APPROVED
Limited building only review.
Permit holder responsible for full compliance with the code.

GIETZ RESIDENCE
2780 NORRINGTON RD.
LILLINGTON, NORTH CAROLINA

FOUNDATION PLAN

Sheet
S1.0

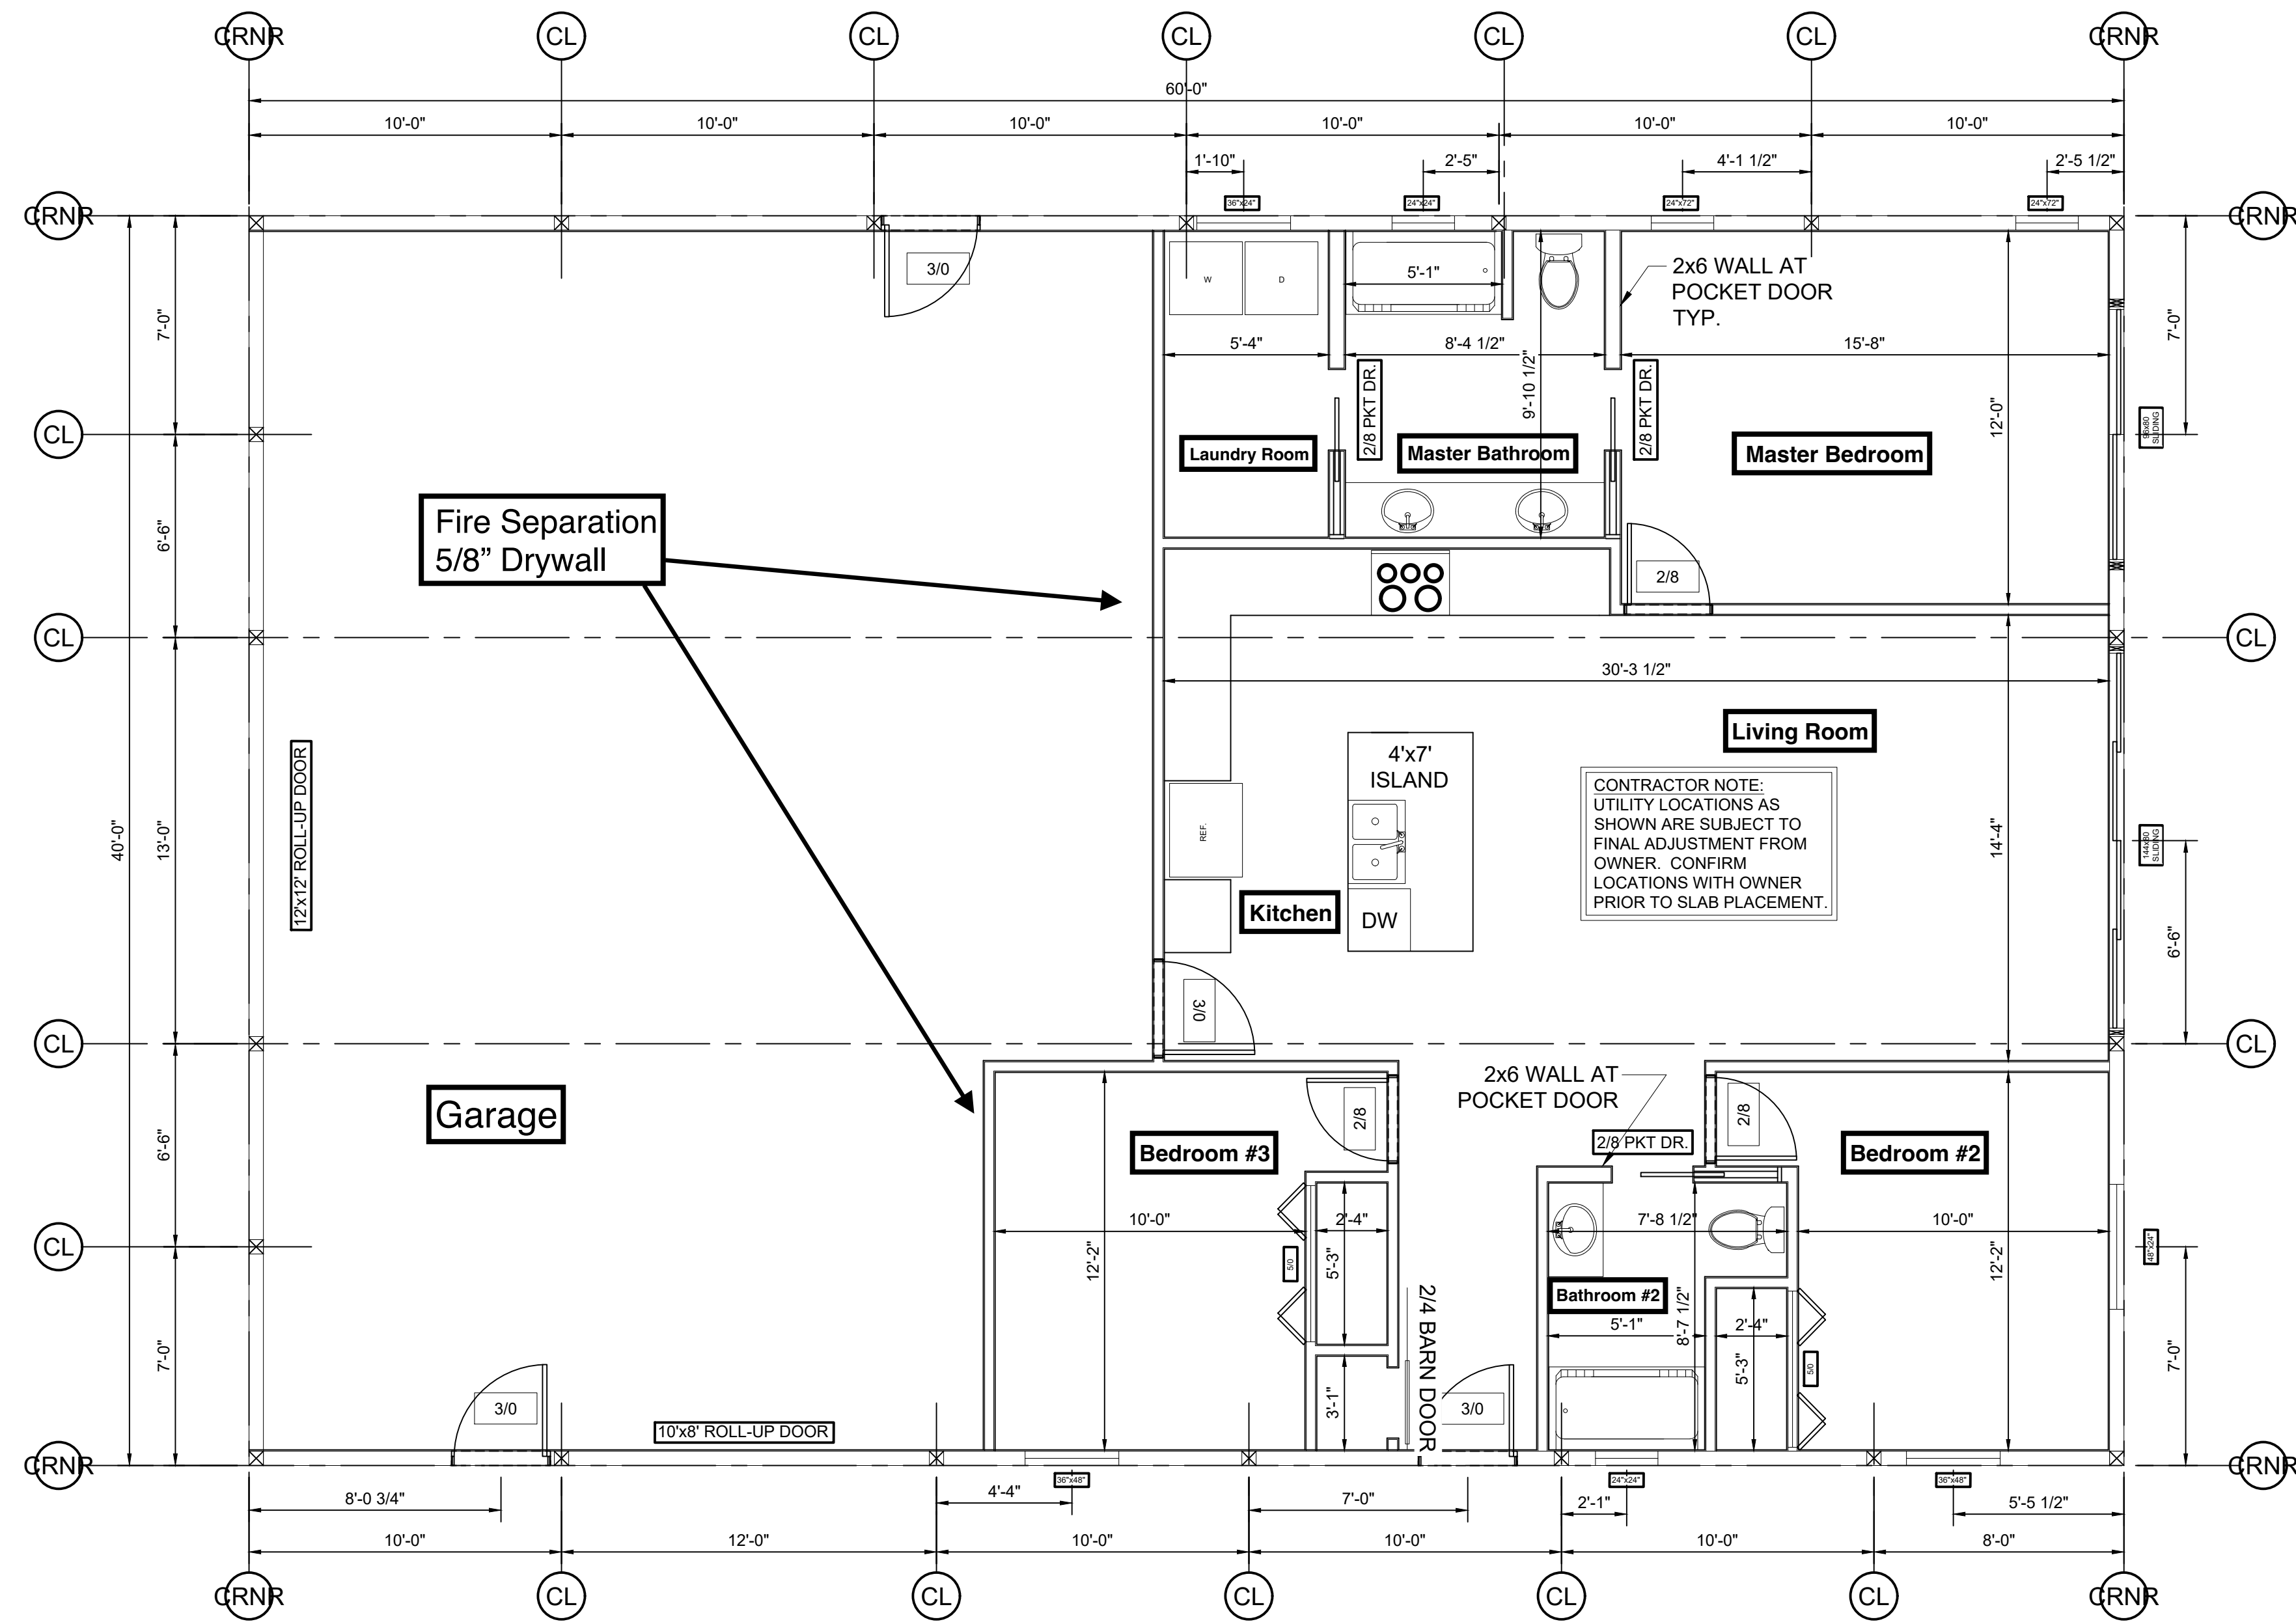
Shall be slab to roof deck, or garage ceiling fully covered.
Fire Separation
 5/8" Drywall

Solid exterior door, no glass.

At least one egress window in each bedroom. Window shall have minimum 5 sq ft of total glass area, the following three individual requirements shall also be met.

1. Minimum 4 square foot opening clear.
2. Minimum opening height shall not be less than 20" clear.
3. Minimum opening width shall not be less than 22 inches clear.
